September 22, 2024

Re: Sunroom Addition
479 D.L. Phillips Lane
Broadway, North Carolina

OTG Consulting, PLLC (OTG) was requested to evaluate the design change for the sunroom addition. We understand that an original structural design was performed by Line on Design, dated April 14, 2023. OTG was requested to review the provided value-engineered design performed by you.

SECTION - ENTRY / SUNROOM

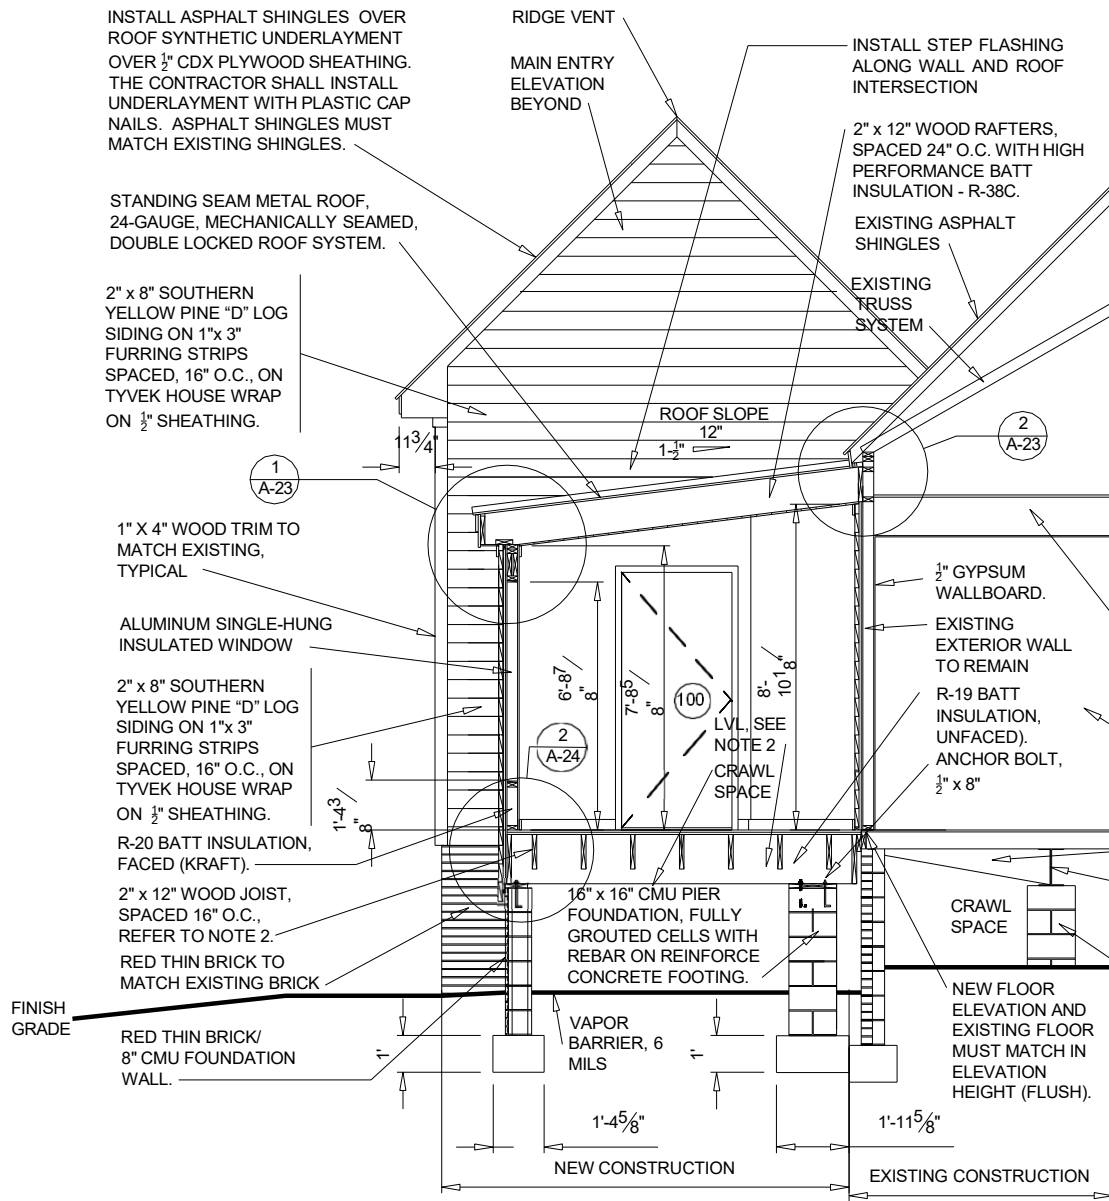
Based on our review of the value-engineered design, the plans are sufficient to support the loads and are in compliance with NC Residential Building Code. OTG recommends that the 6x6 post or (3) 2x6 SPF posts be spaced no more than 8 feet apart and located on a CMU pier for proper load path to the foundation.
